Application No: BE/149/20/PL
Site Address: 339 Chichester Road Bersted PO21 5AN
Description of works: Replacement of blockwork boundary wall with fence & new vehicular access. This site is in CIL Zone 4 (Zero Rated) as other development.

Thank you for your internet representation made on 17th January 2021 which has been recorded as an objection with the comments as follows:

SITE PLAN

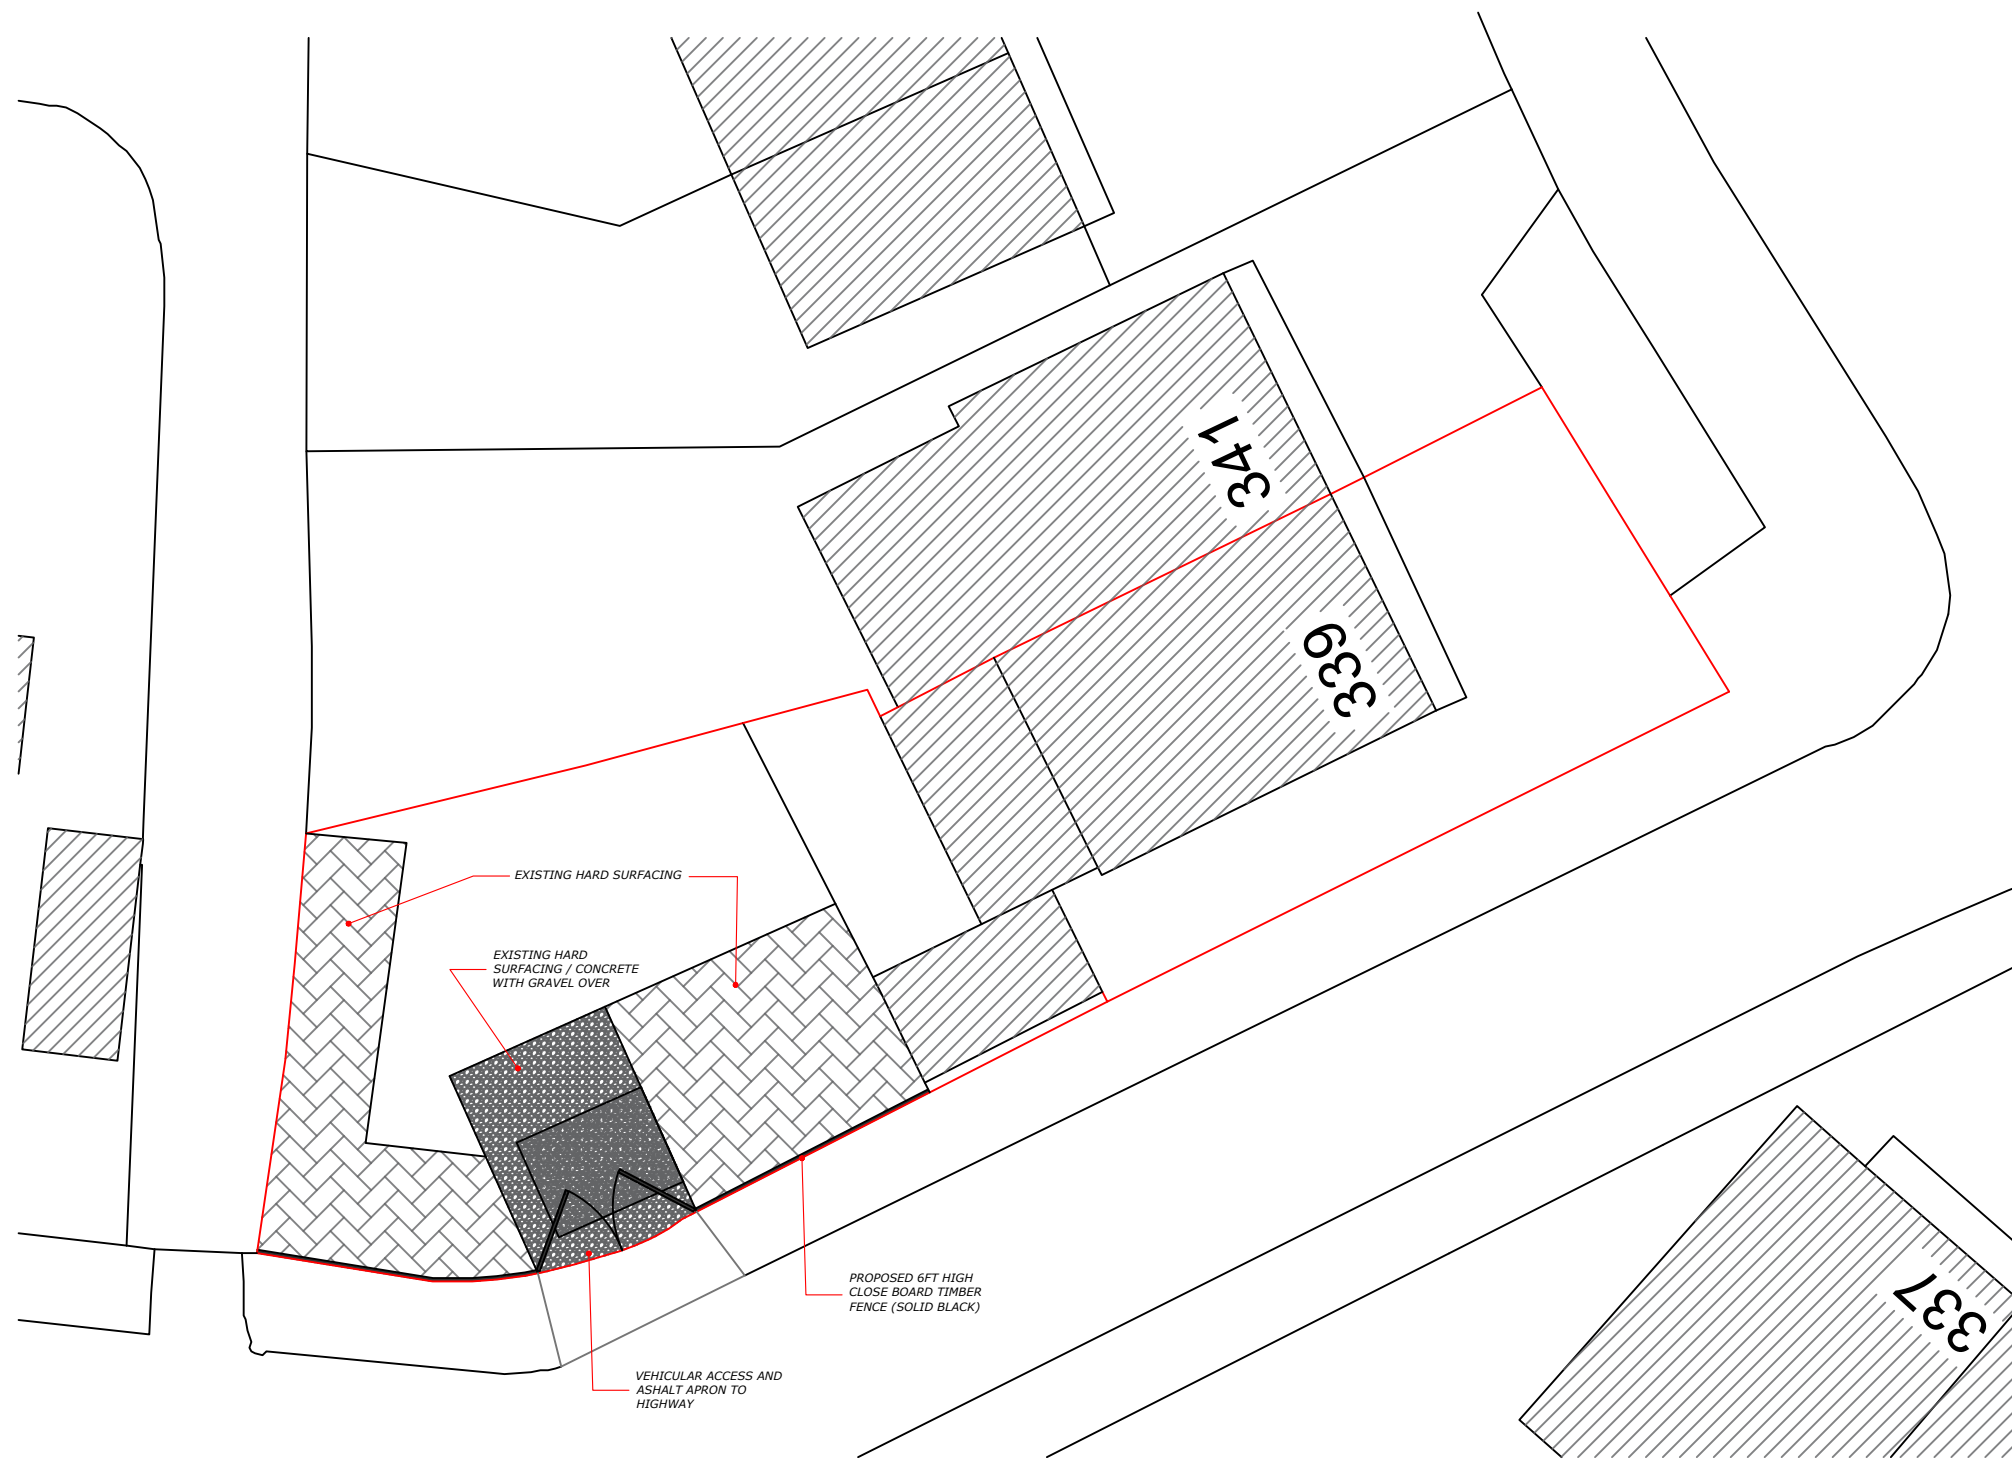
The proposal for vehicle cross over and off road parking is unacceptable, bearing in mind the clear visibility to either side that entering/exiting vehicles would enjoy and which would be in forward gear at all the time.

There's also no adequate visibility so other road users/pedestrians to see potential hazards in time to slow down or stop comfortably before they reach it.

Parking is already at a premium, the proposed plans would take many parking spaces away from the residents of Bedford avenue. 339 Chichester road already enjoys off road parking to the front of property for more than one vehicle.
